# ENG-PPR19009-R3-GEC.pdf Markup Summary

Engineering Review  
09/06/2019 1:36:36 PM  
dsdrice  
JedRice@epcplanning.com  
07/19/2017  
EPC Planning & Community  
Development Department

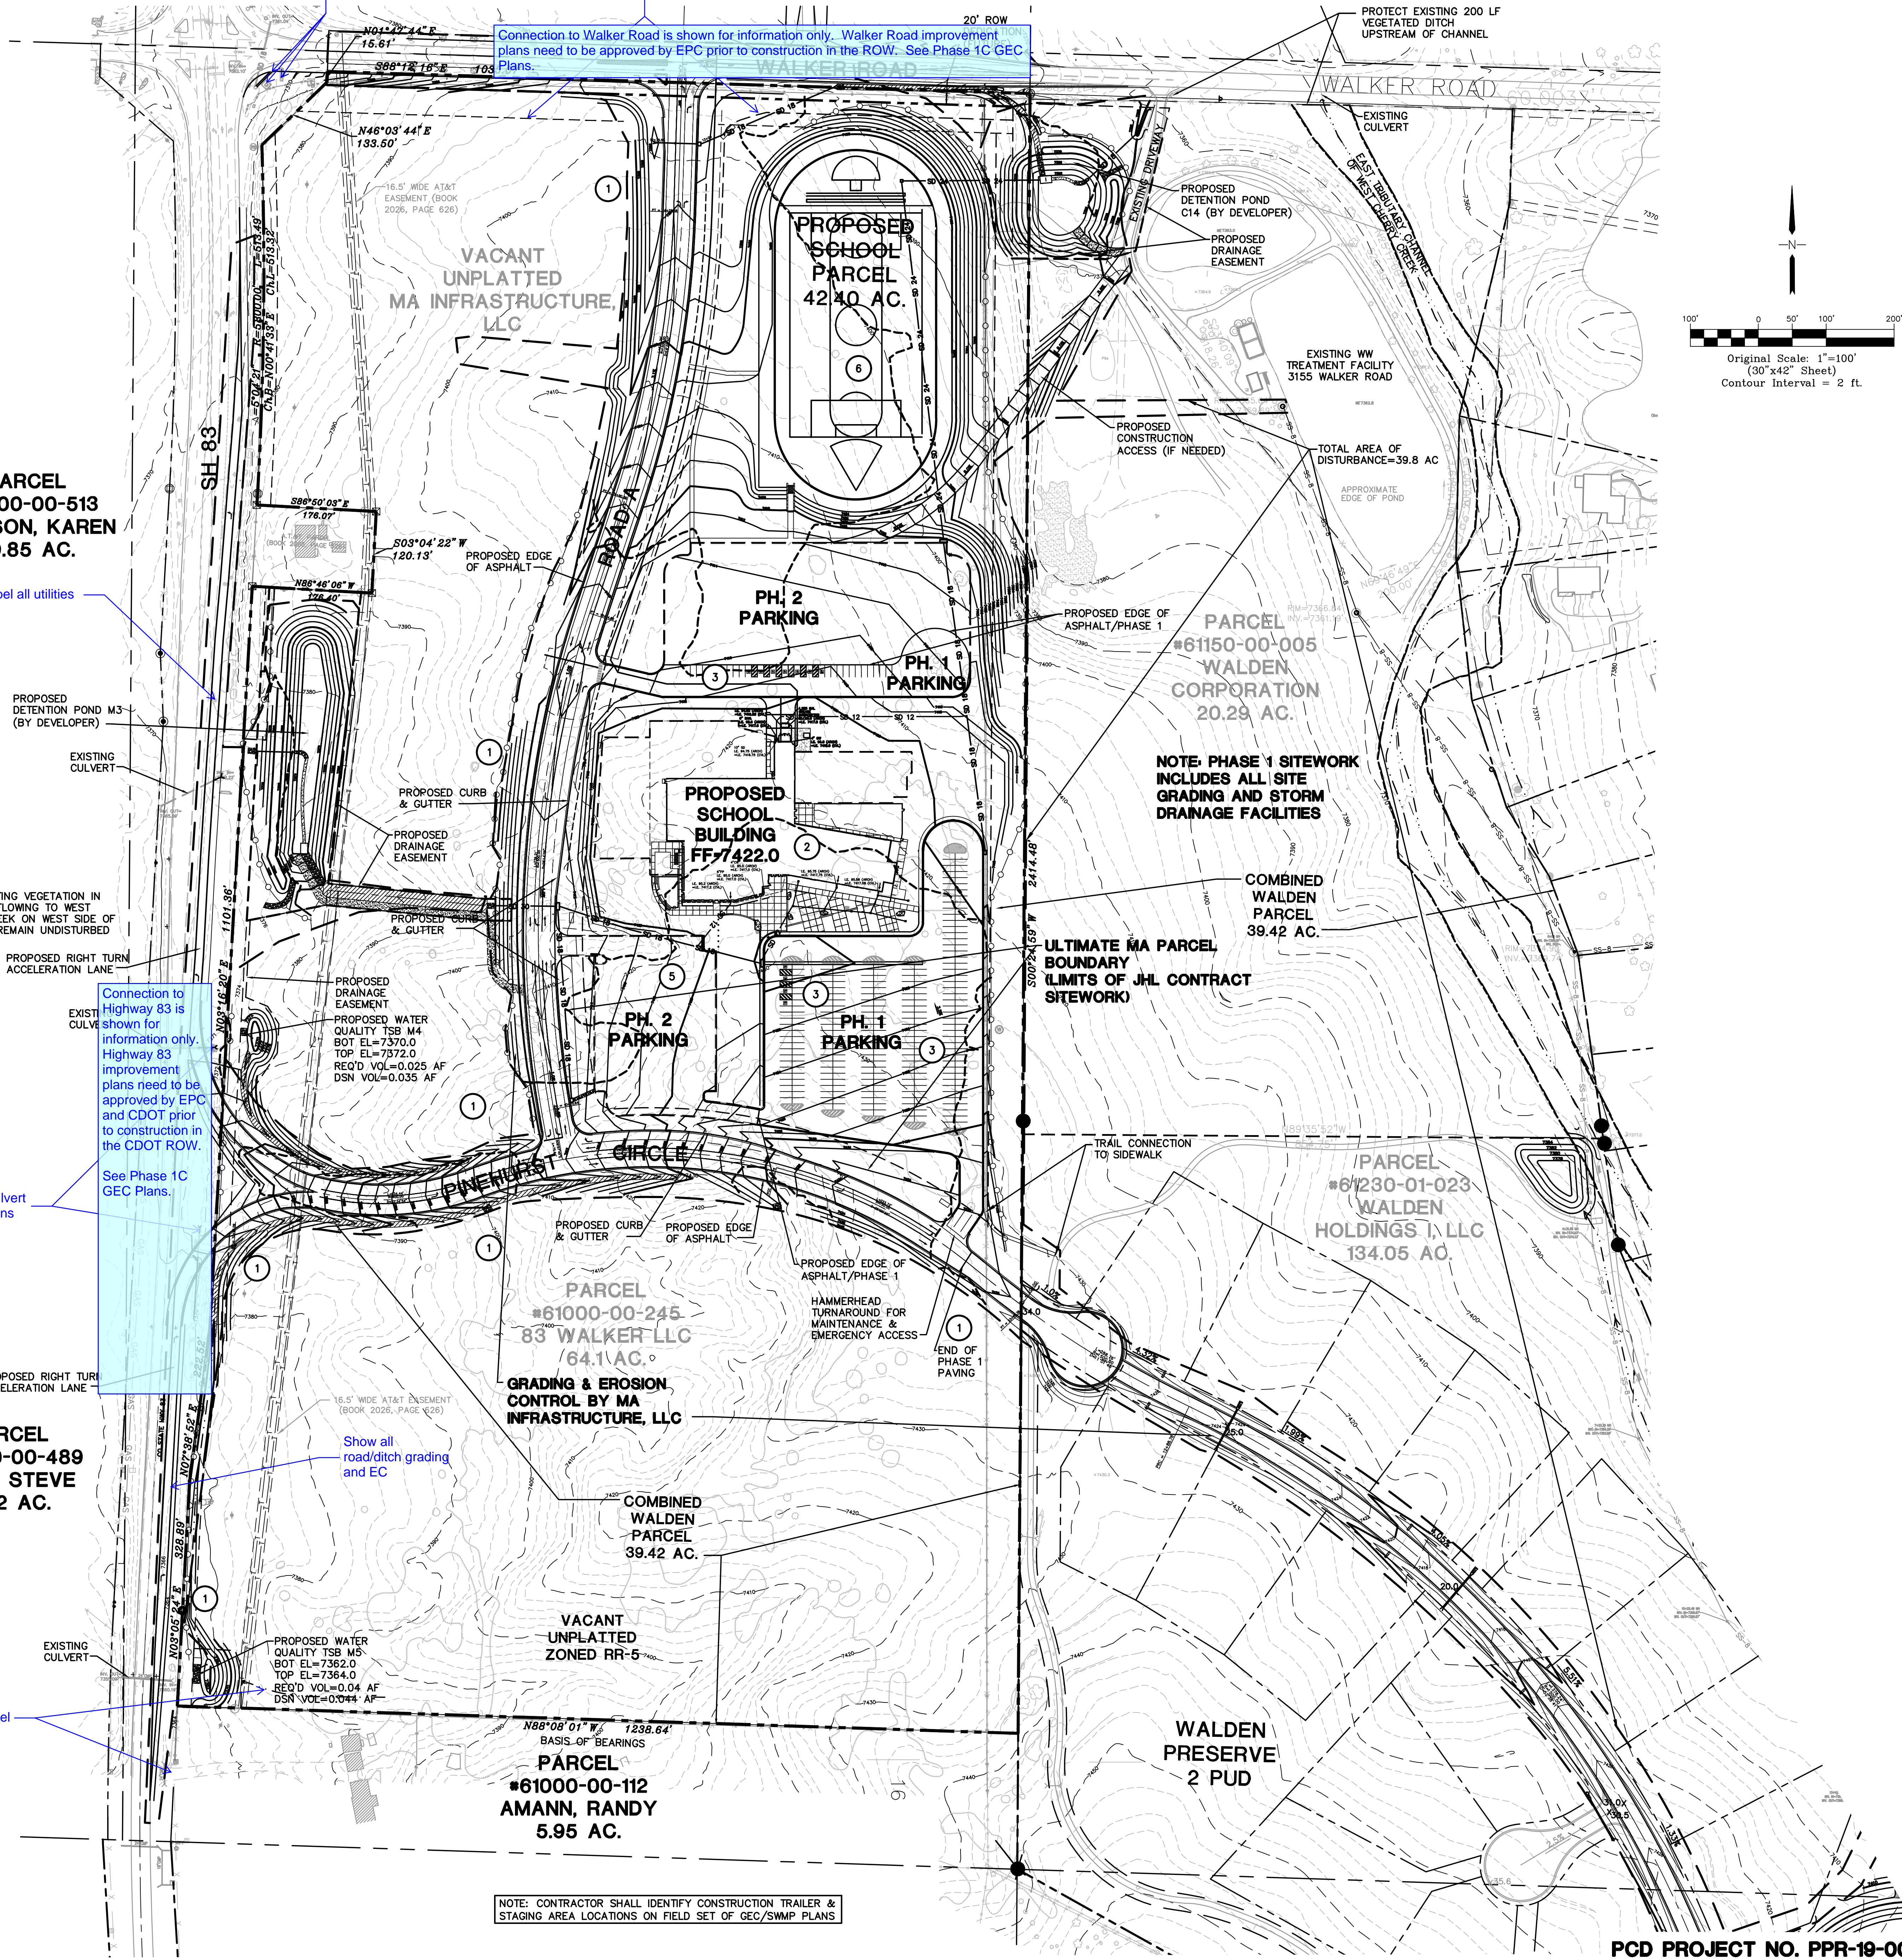
Label all utilities

Show all road/ditch grading and EC

Connection to Walker Road is shown for information only. Walker Road improvement plans need to be approved by EPC prior to construction in the ROW. See Phase 1C GEC Plans.

Label culvert extensions

Connection to Highway 83 is shown for information only. Highway 83 improvement plans need to be approved by EPC and CDOT prior to construction in the CDOT ROW.
